Appeal Decision

Appeal Ref: APP/R5510/D/19/3234767

3 Frithwood Avenue, Northwood, HA6 3LY

- The appeal is made under section 78 of the Town and Country Planning Act 1990 against a refusal to grant planning permission.
 - The appeal is made by Joanna Fuller against the decision of the Council of the London Borough of Hillingdon.
 - The application Ref: 7296/APP/2019/1485 dated 3 May 2019, was refused by notice dated 2 July 2019.
 - The development proposed the erection of a shed style dormer extension to existing habitable roof space.
-

Proposed Rear Elevation
Scale 1:50

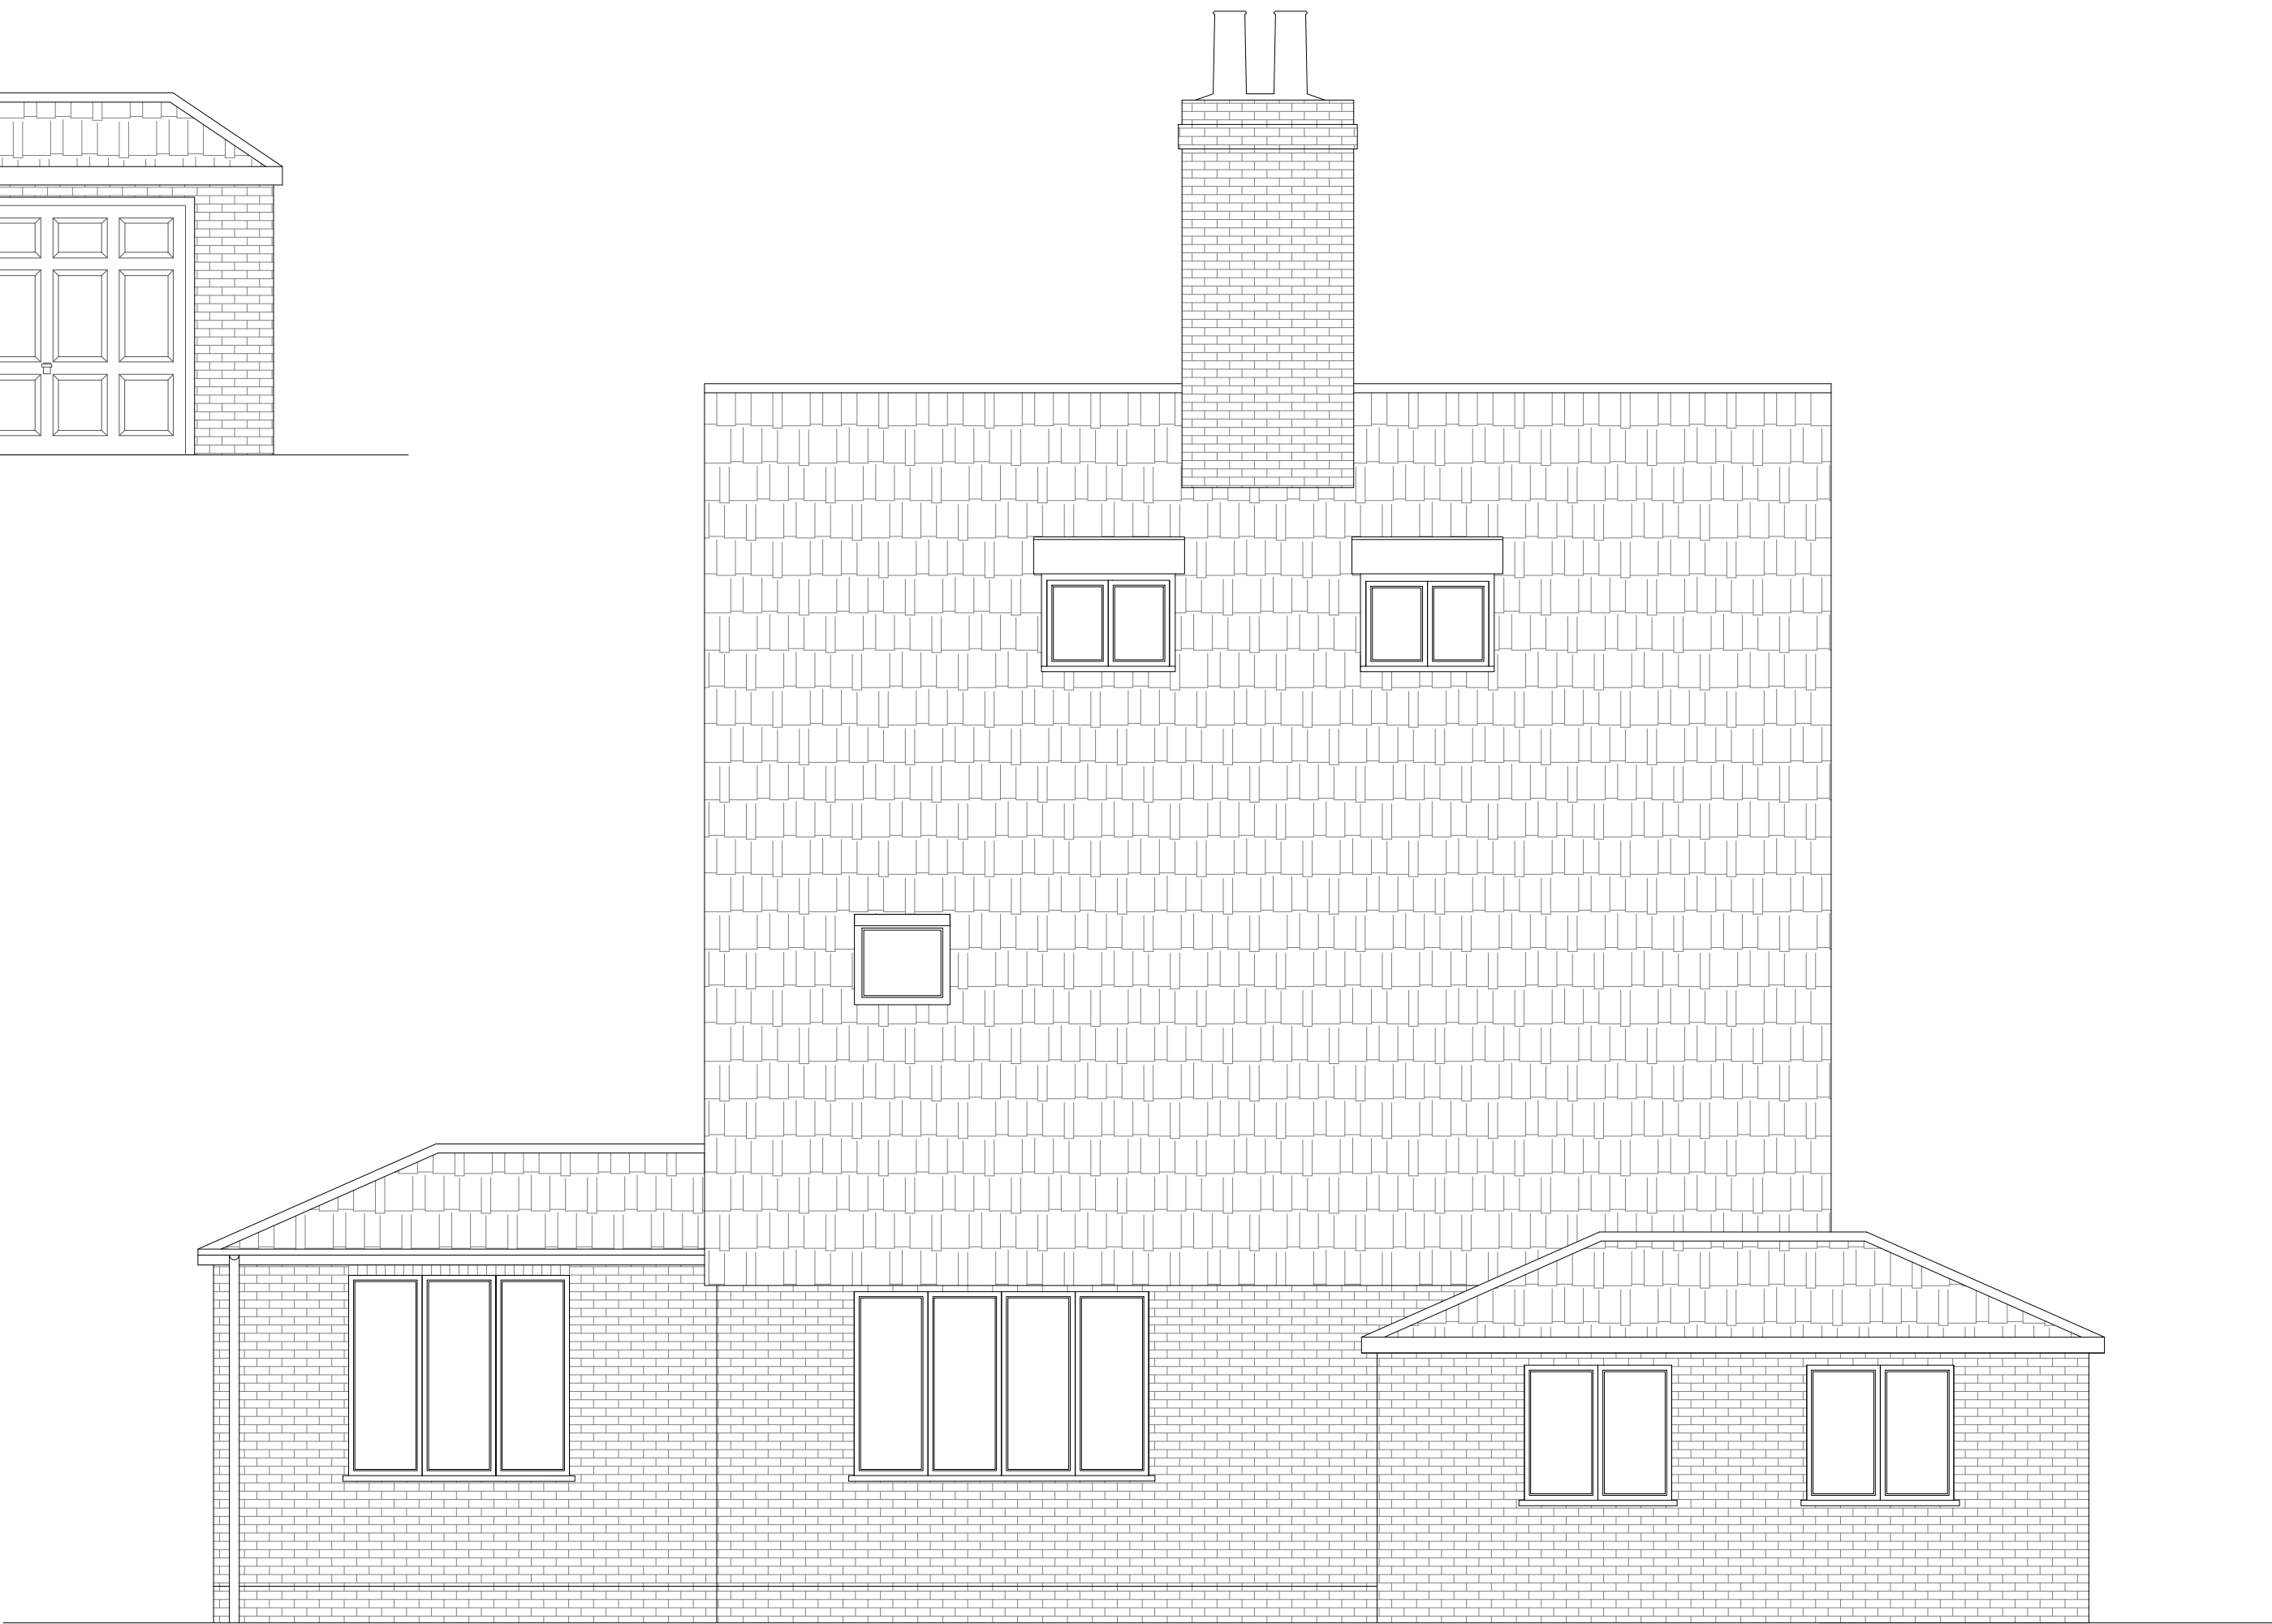
5. The main section of the rear roof would accommodate the proposed dormer and window, between a large cross-gable and a modestly sized first floor window partly set into the roof. The proposed dormer structure would be a sizeable addition to the roof slope with the top of the dormer structure tapering

- into the main roof slope below its ridge at the same height as the ridge of the cross-gable, and at its base would taper into the roof approximately 1.5m above the eaves. The roof of the dormer structure would be at a shallow pitch which would not relate well and not be in keeping with the steeper main roof pitches. Whilst the cross-gable would provide a degree of screening, the proposed dormer would appear as a significant extrusion, with different shapes, proportions, angles and window alignment. This would be out of keeping with and harmful to the character and appearance of the host dwelling.

9. Visibility of the proposed development would be limited to the rear and side of the dwelling, largely restricted to neighbouring and nearby dwellings and their gardens. However, by reason of its height, shape and proportions it would neither preserve or enhance the character or appearance of the NFCA, and would cause a small amount of harm to an element of the NFCA that makes a positive contribution to its significance.
